Hassell © December, 2021

AGENDA Response to feedback

AMRF - First Building

1 ELEVATION - SOUTH
1101 1:100

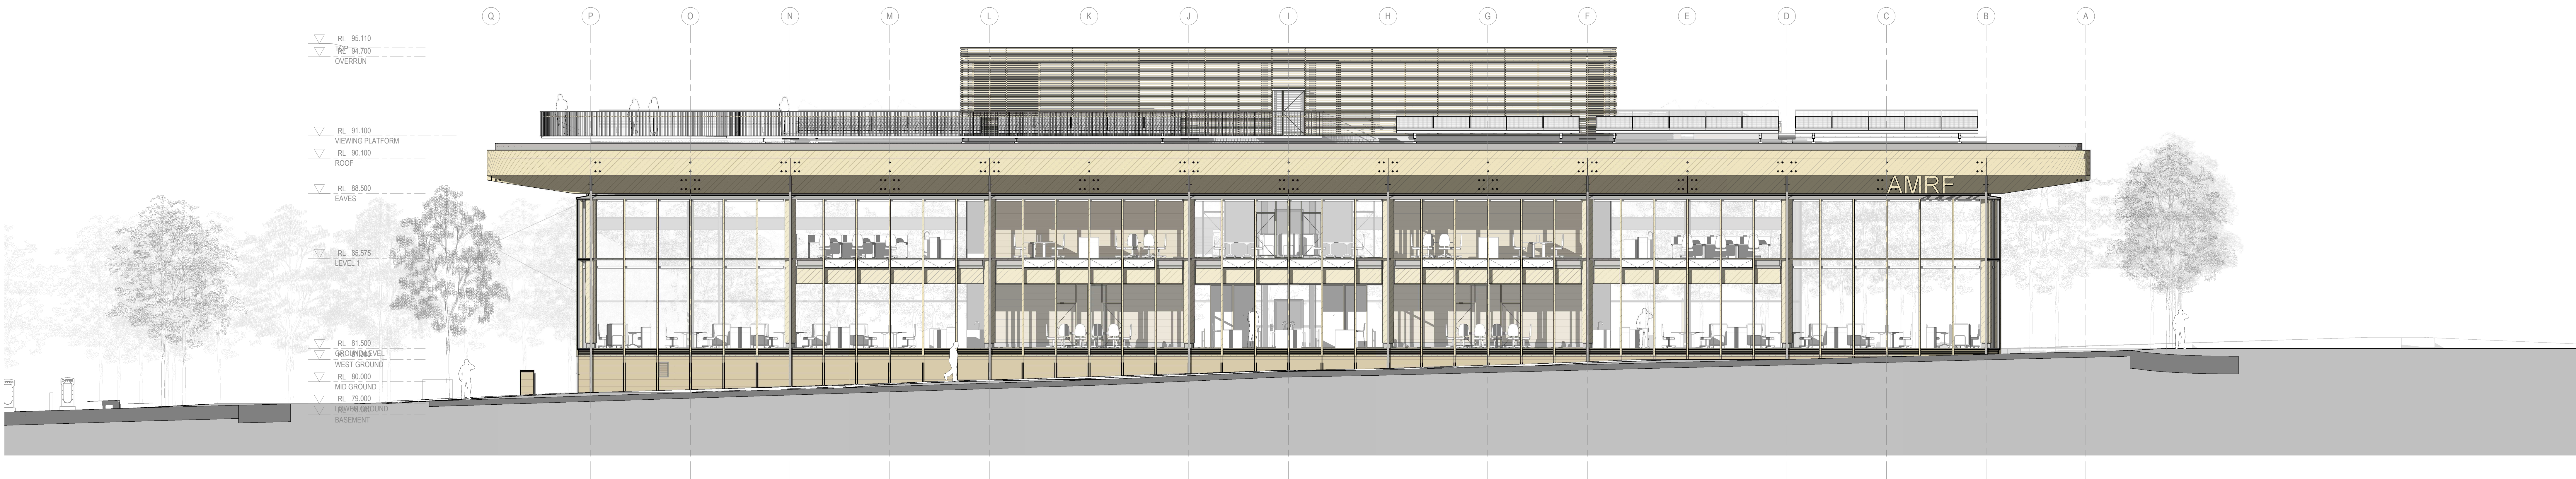
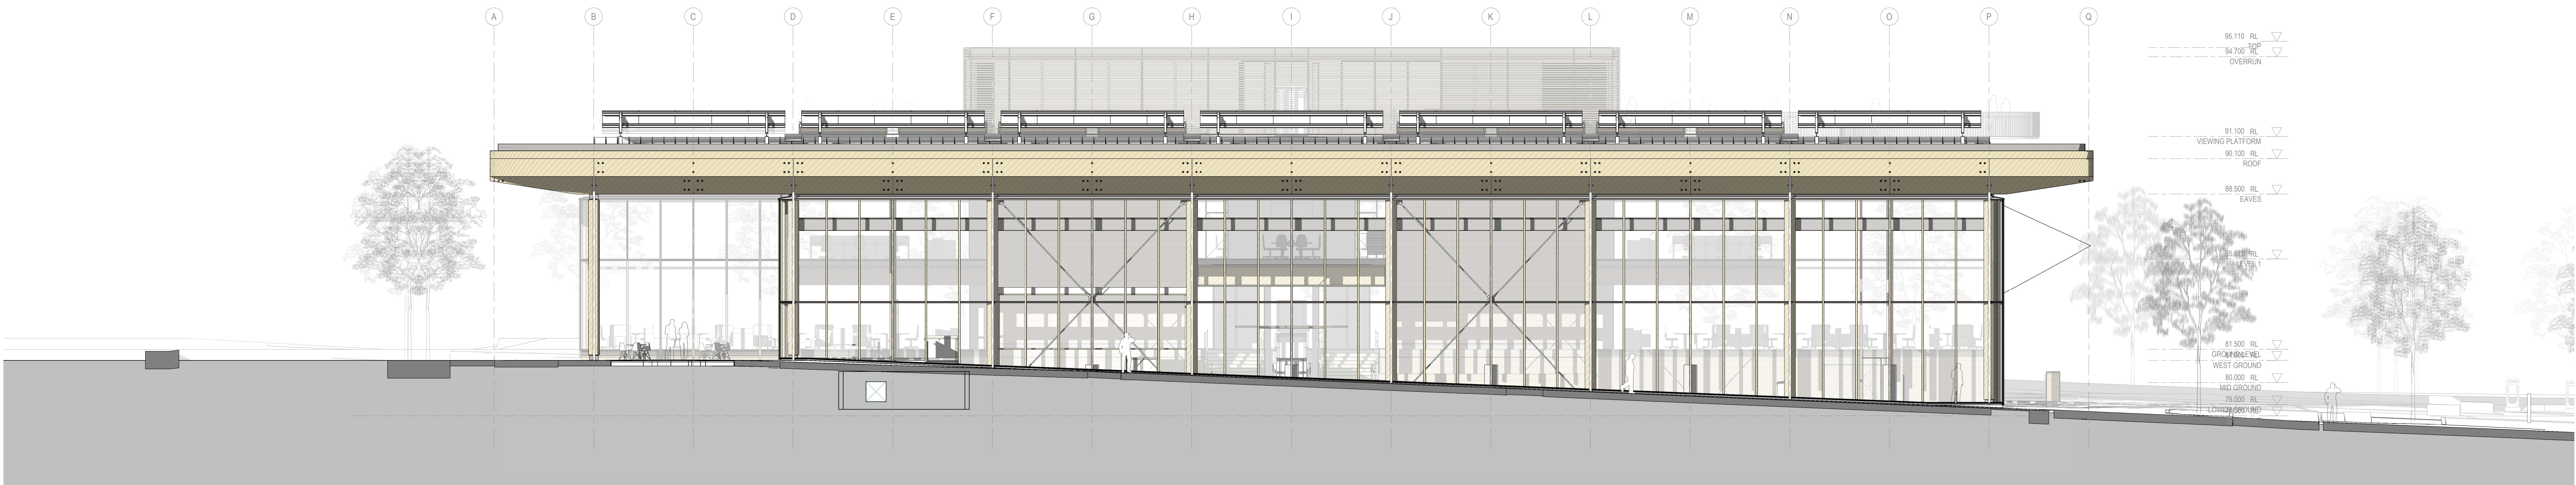
*While the lightness of the built form and visibility of the central open space through the building is supported, the performance of the glass façade in relation to solar exposure/heat (including radiant heat) is of concern.

ARTISTS IMPRESSION - FOUNTAIN WATER FEATURE

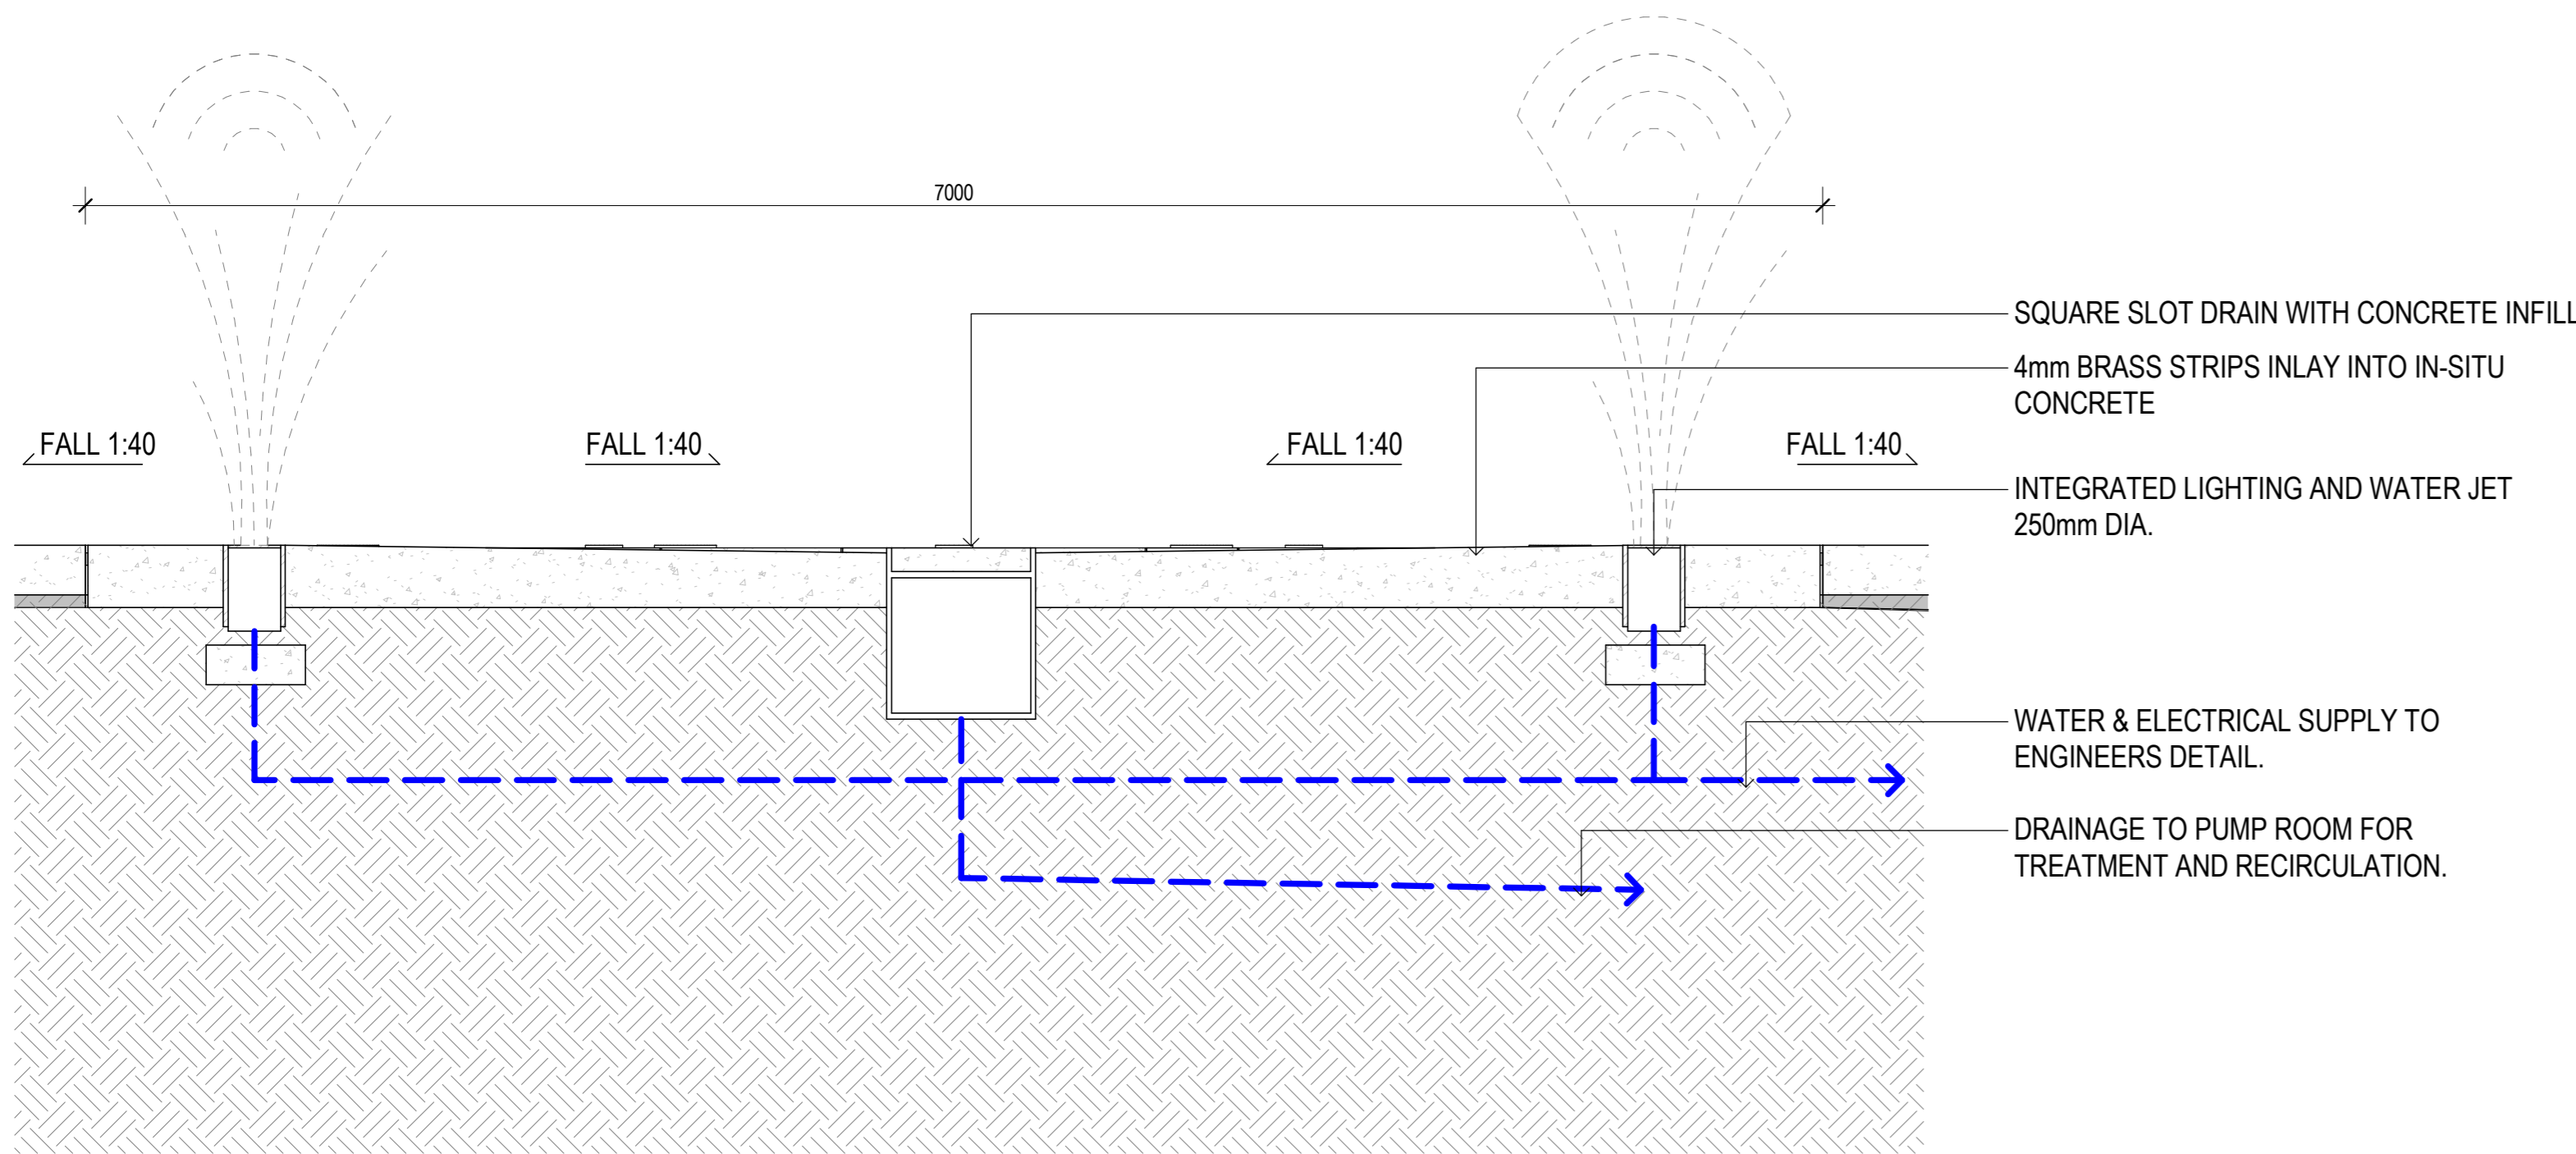
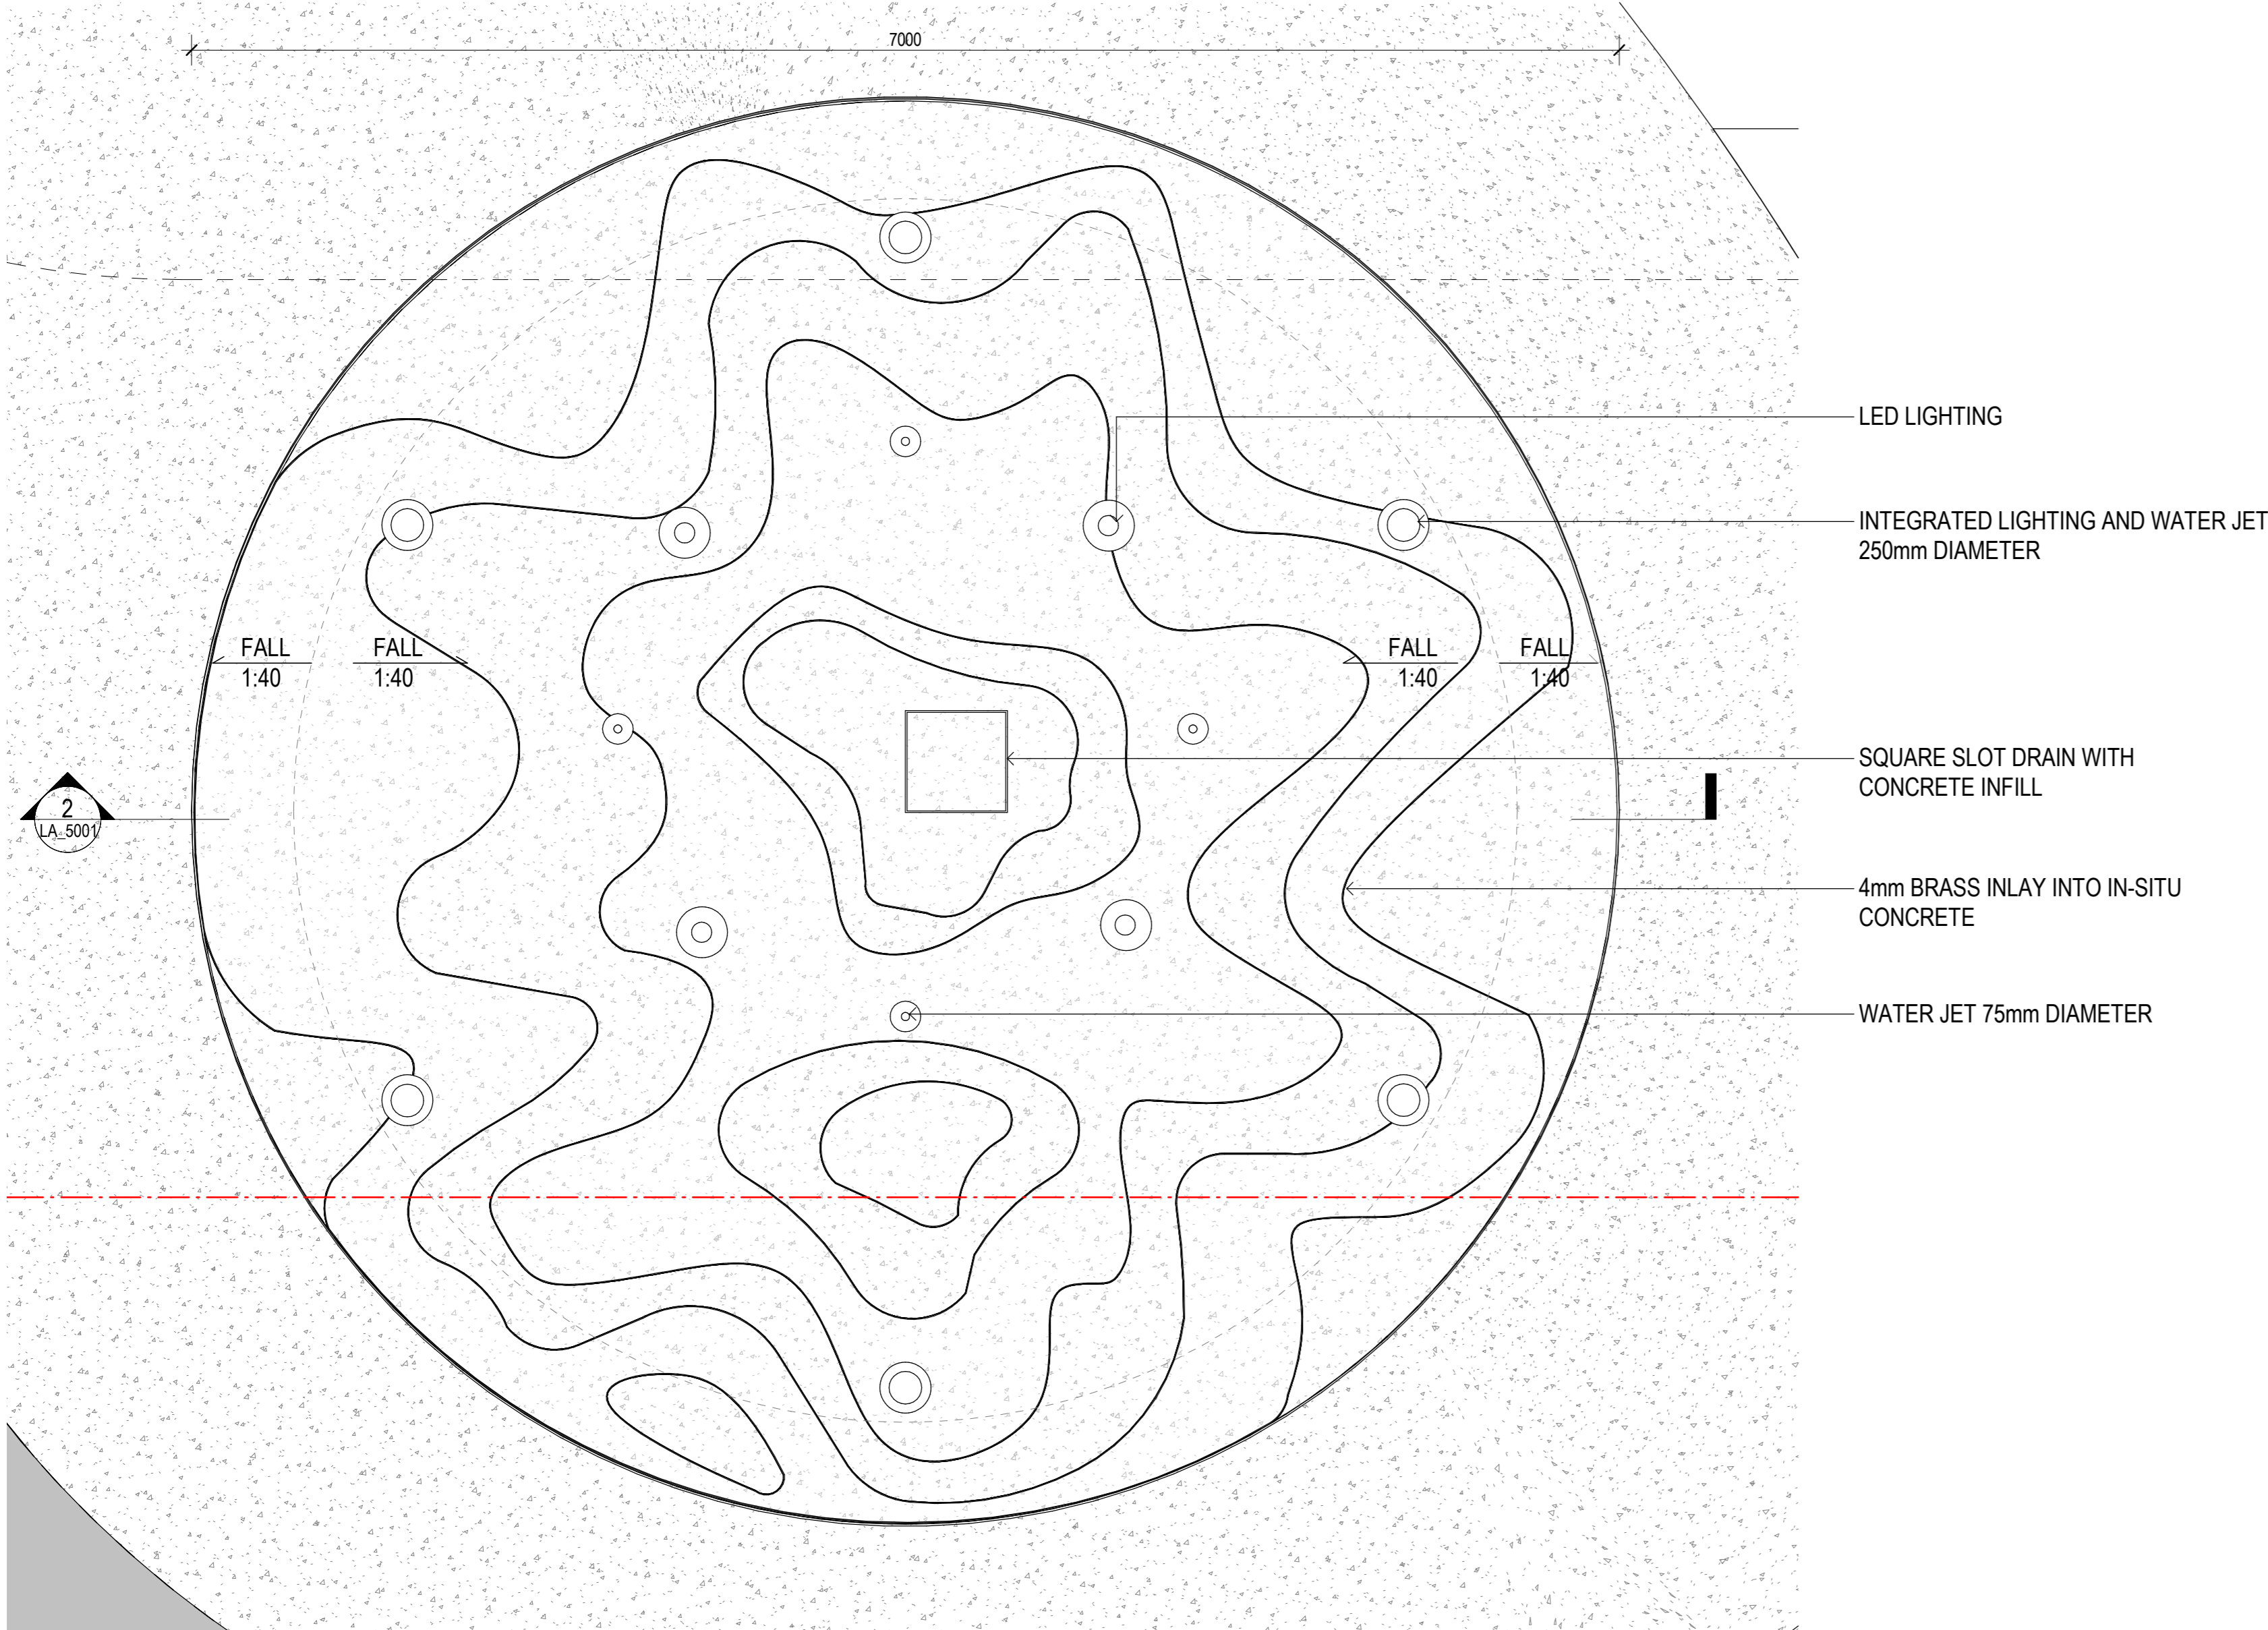
*Strengthen how the water story is reflected in the landscape design. Consider extending the water element into the building.

Water is experienced and celebrated at key moments in the landscape through permanent naturalised basins and sculptural interpretive fluid lines and forms informing the paving and planters.
